Date: 22 November 2023

**Application by Equinor New Energy Limited (“the Applicant”) for an Order granting Development Consent for the proposed Sheringham Shoal and Dudgeon Offshore Wind Farm Extension Project (“the Proposed Development”)**

**REQUEST FOR INFORMATION**

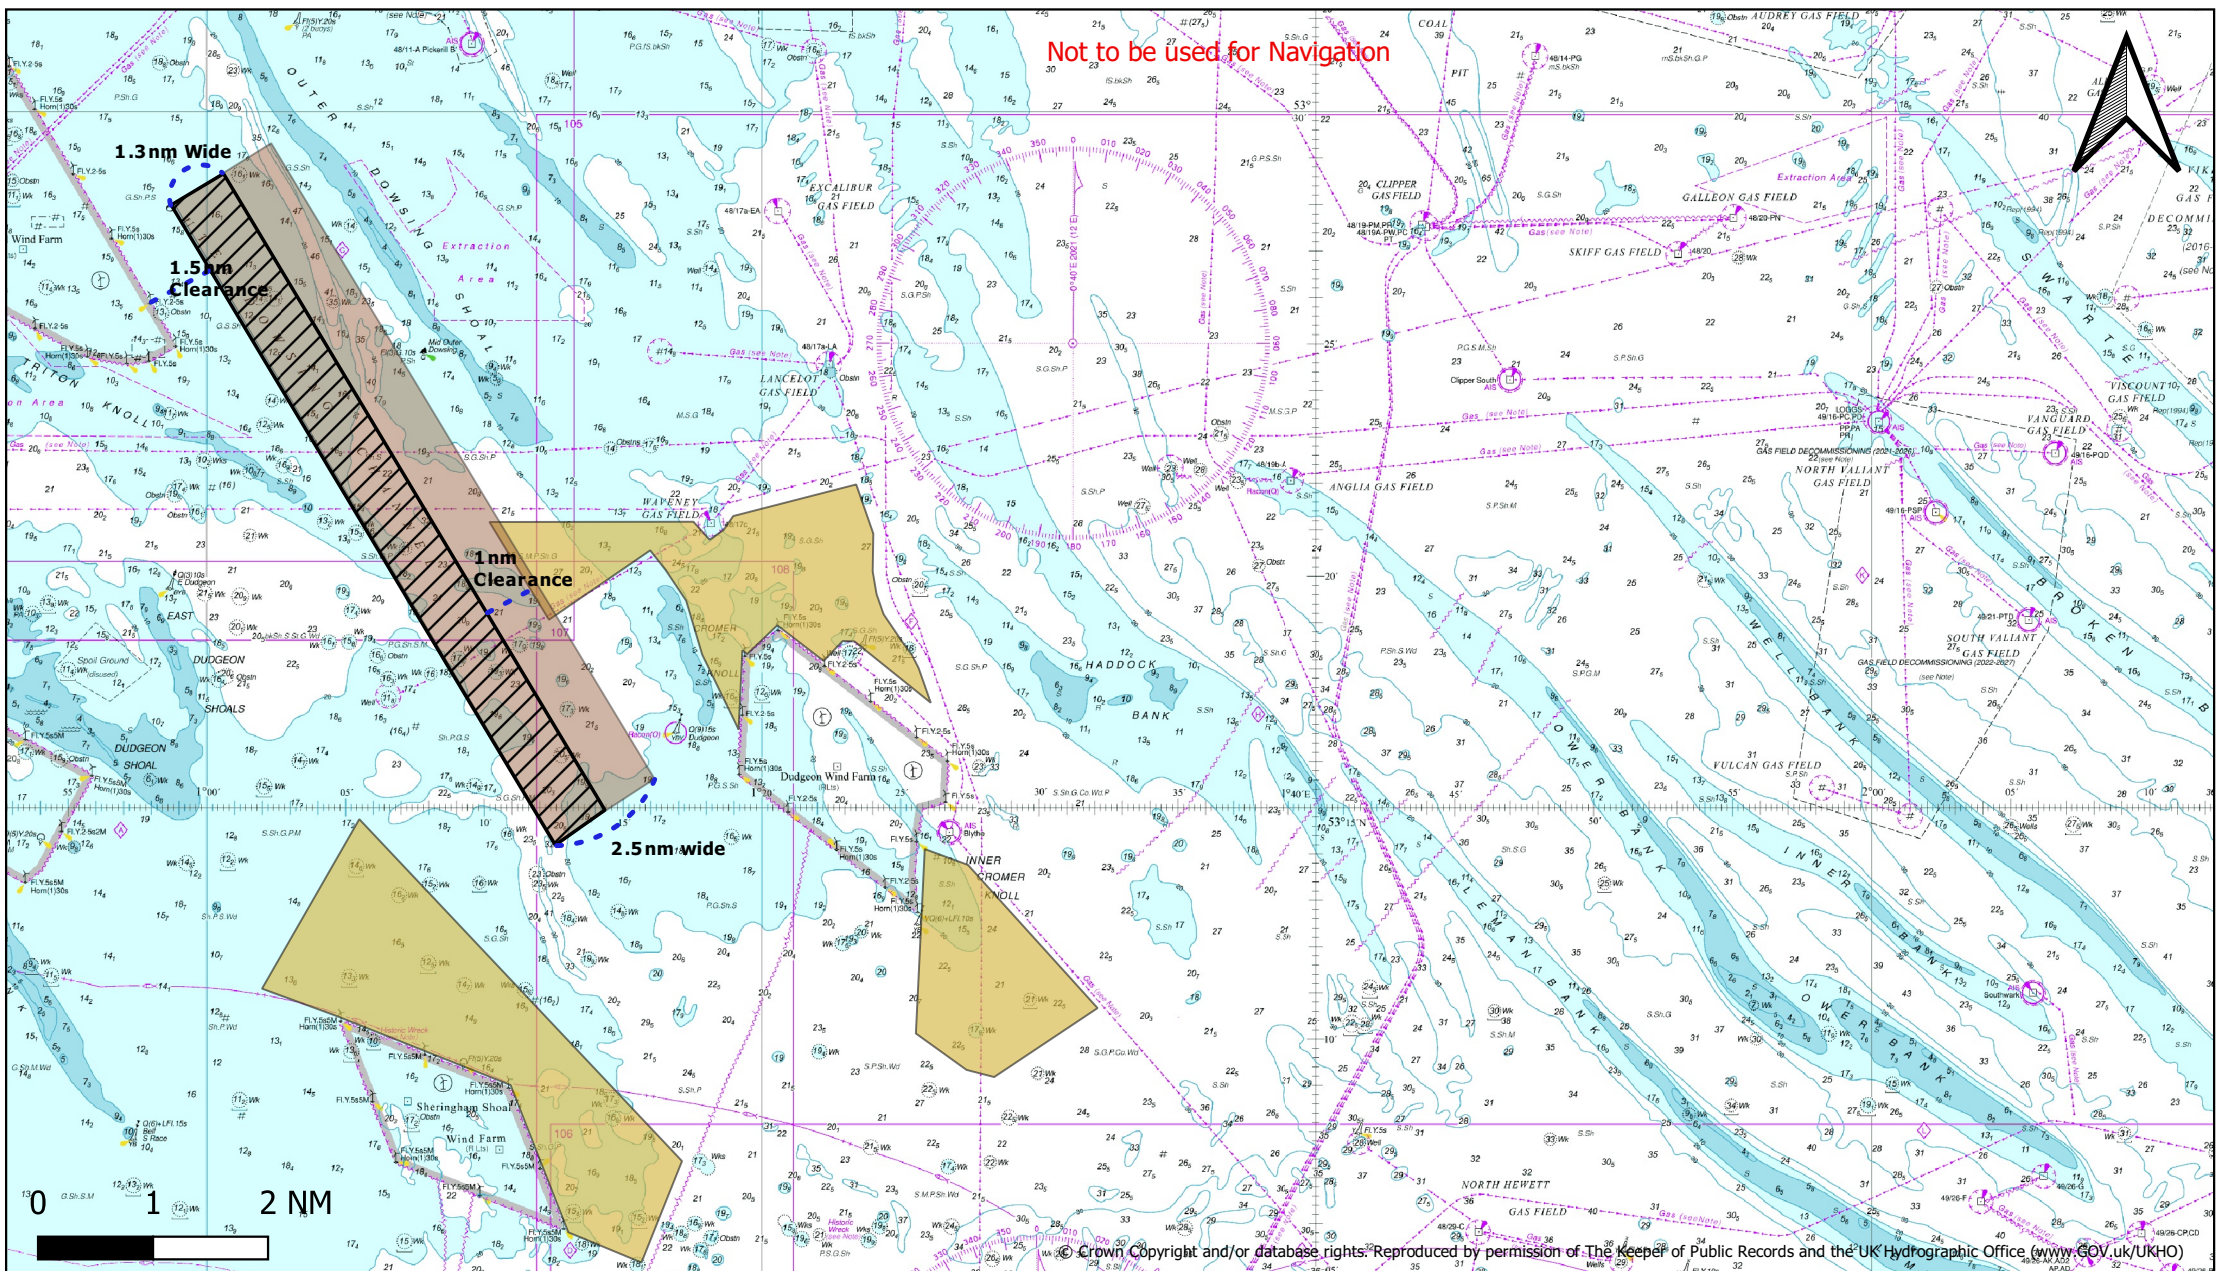
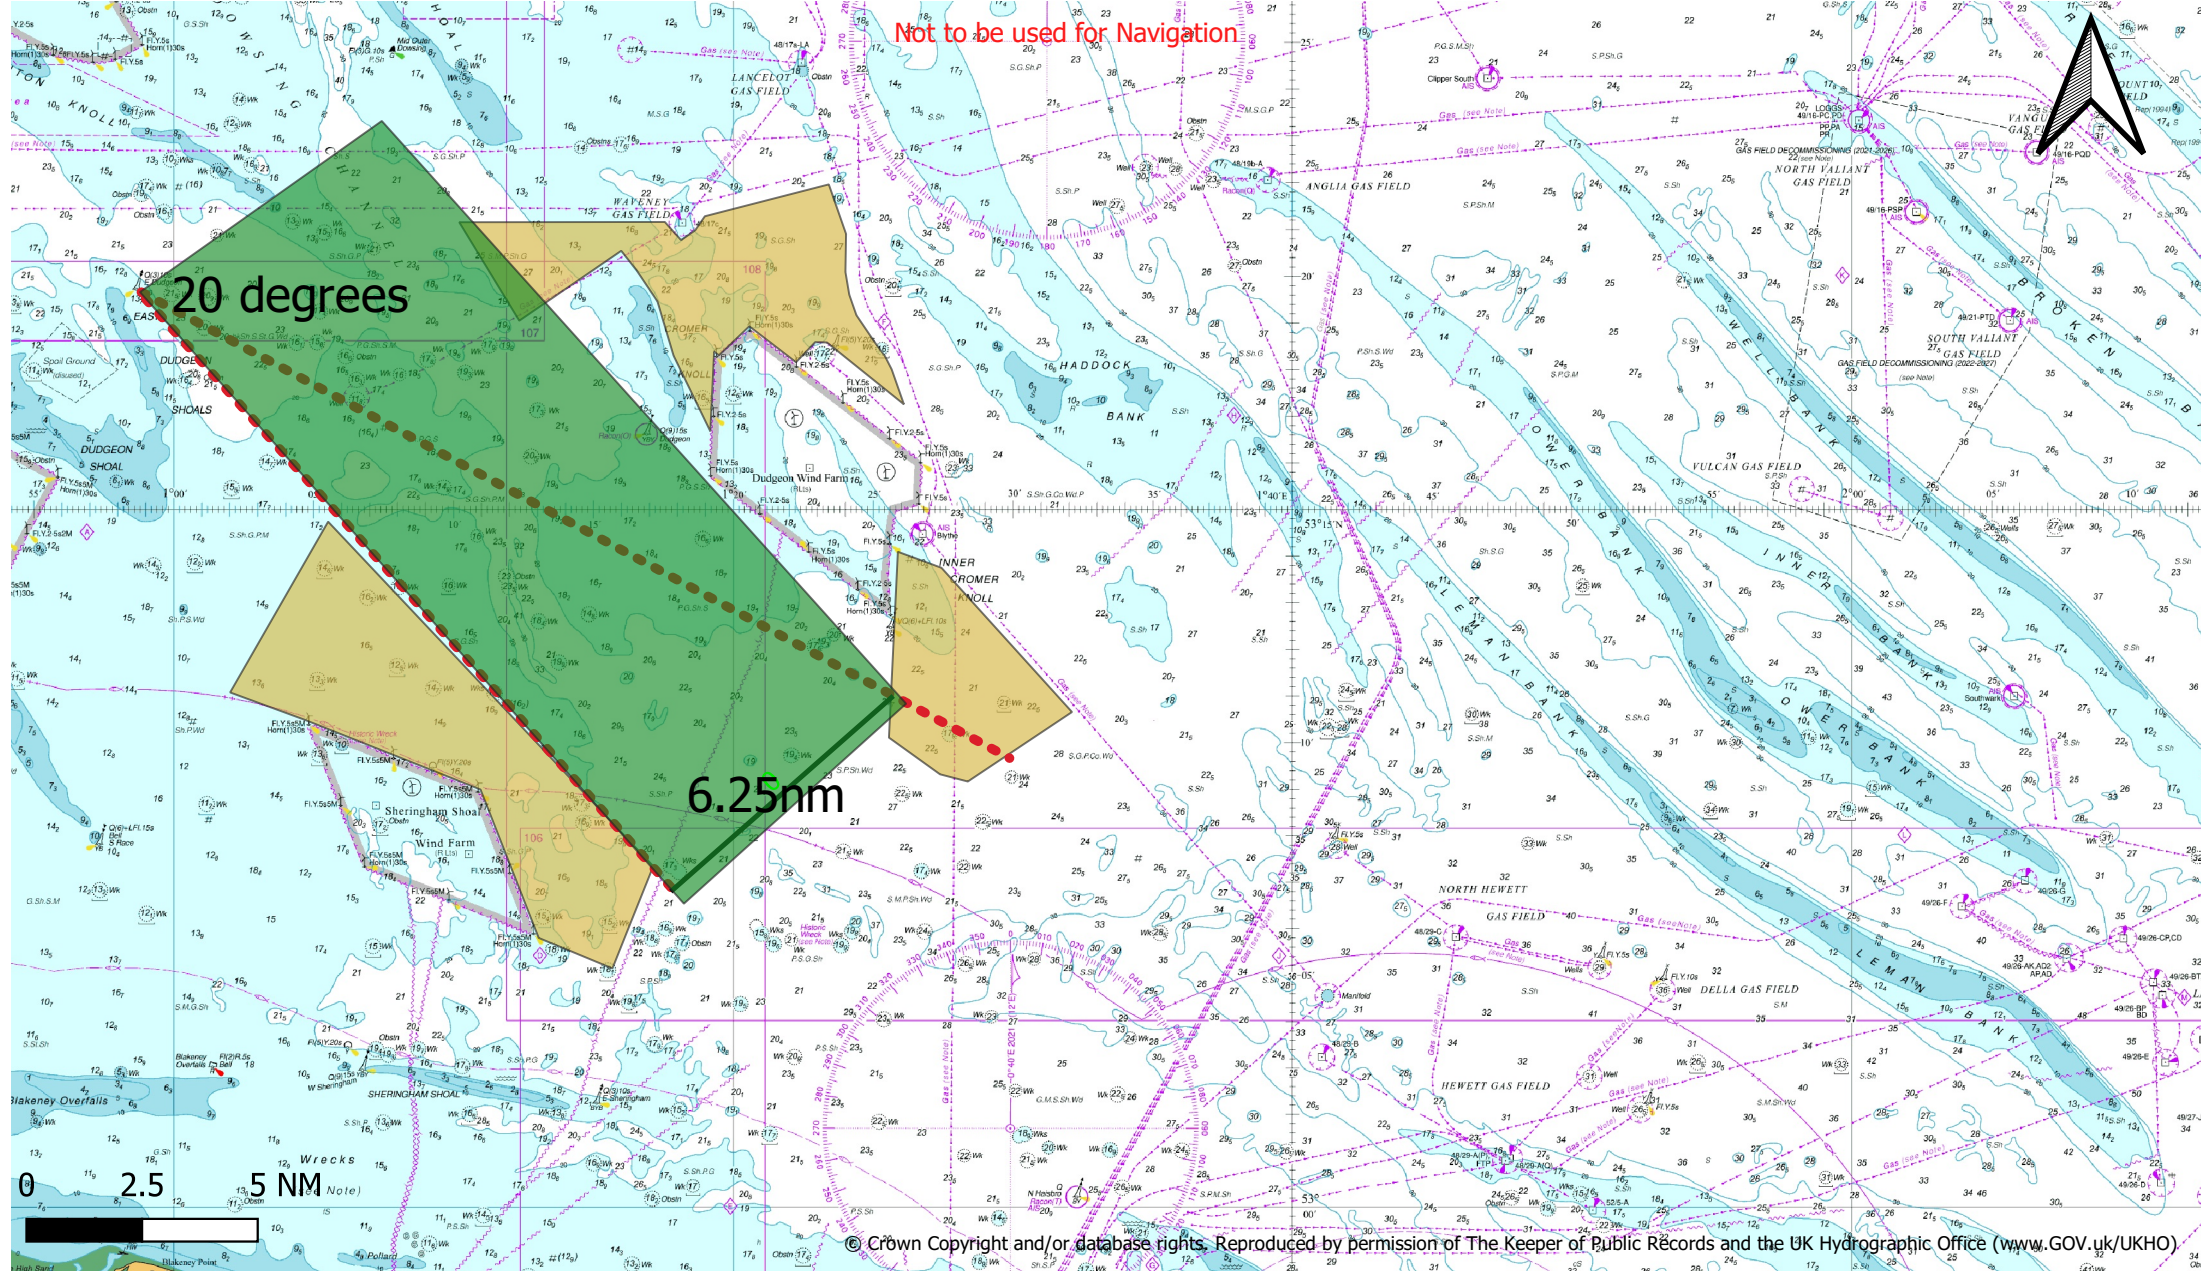
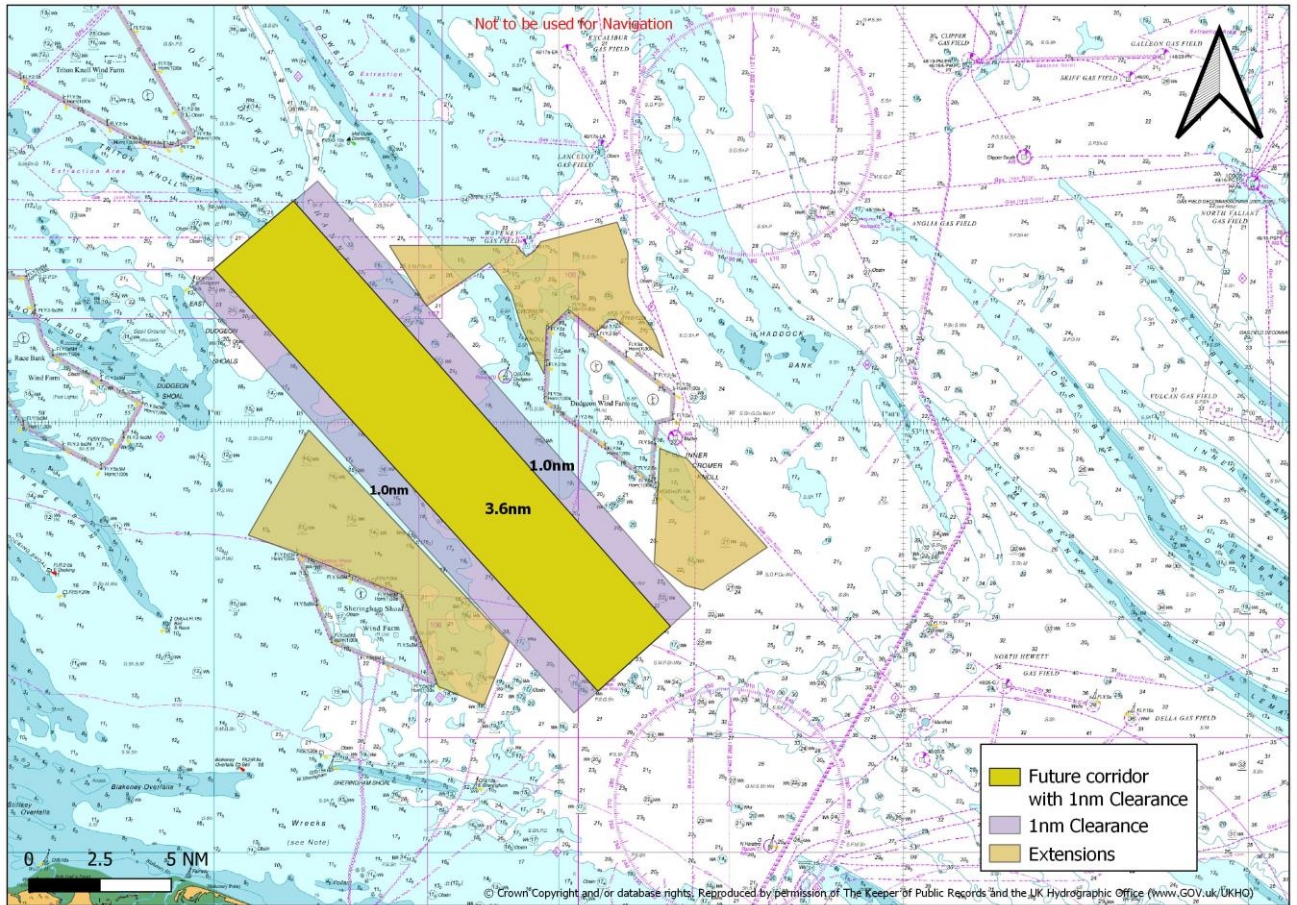
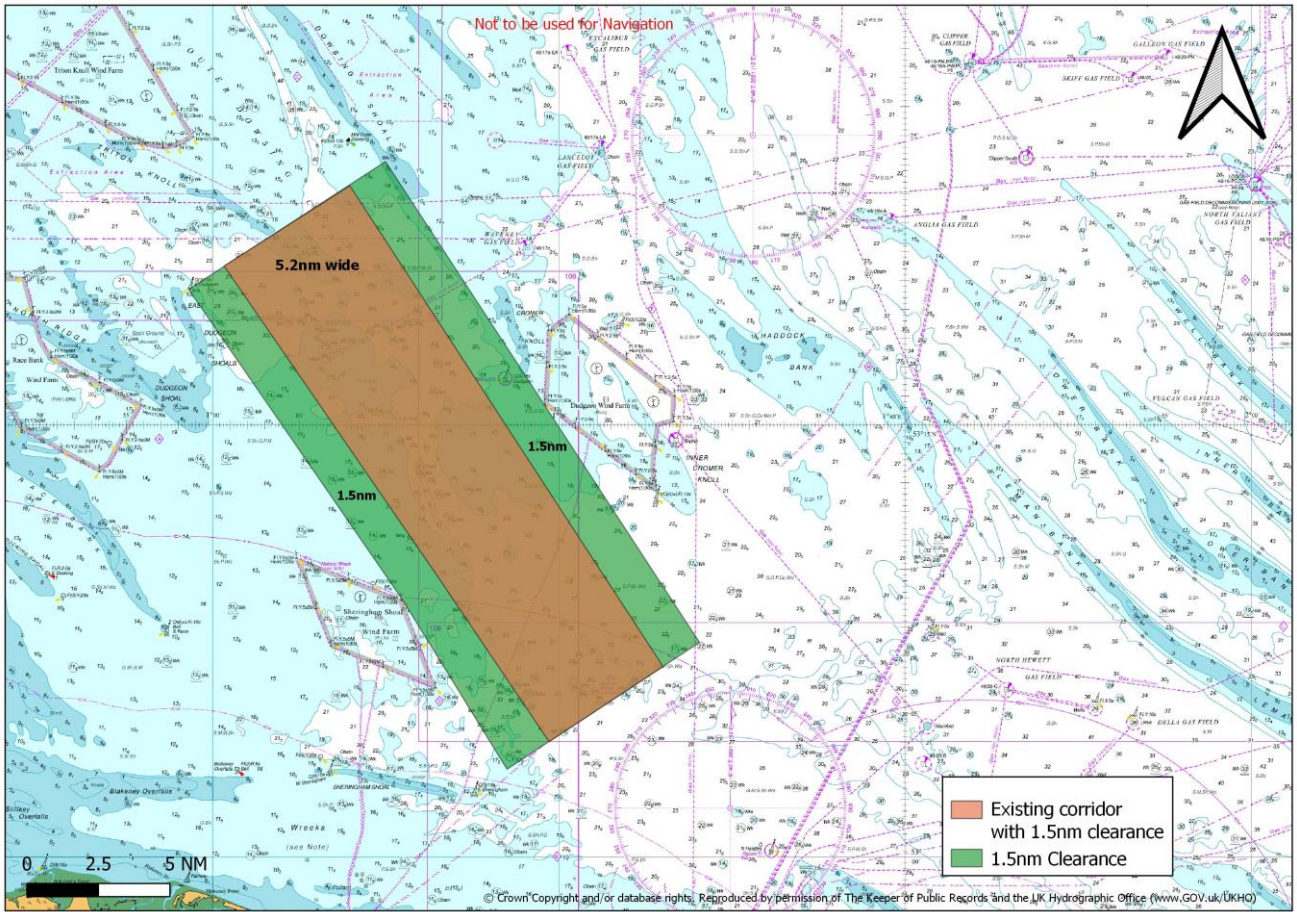
3. The Secretary of State notes the mitigation proposed by the Maritime and Coastguard Agency (“MCA”) in the form of an obstacle free zone. **The Applicant**

and **the Maritime and Coastguard Agency** are invited to confirm their positions on such wording either as a condition in the Deemed Marine Licenses and/or a requirement in Schedule 2 of the Development Consent Order (“DCO”). In particular, comments are requested on the Works or infrastructure to which such a condition should apply. Confirmation should also be provided as to whether the coordinates set out below, in particular suggested amendments to the NE and SE corner, are correct:

*No infrastructure [listed in Work No. XX] shall be installed within the area defined by the coordinates as specified below and no part of any wind turbine generator, including its blades, may overfly into the area:*

<i>Point ID of the area</i>	<i>Latitude (D°M.MM')</i>	<i>Longitude (D°M.MM')</i>
<i>A (NW corner)</i>	<i>53° 21.1541' N</i>	<i>1° 10.1853' E</i>
<i>B (SW corner)</i>	<i>53° 19.0449' N</i>	<i>1° 12.3327' E</i>
<i>C (NE corner)</i>	<b>53° 21.1558' N</b>	<b>1° 11.8346' E</b>
<i>D (SE corner)</i>	<b>53° 19.5696' N</b>	<b>1° 13.6102' E</b>

4. **The Applicant** should also provide revised works plans to reflect the condition/requirement set out at paragraph 5 above.
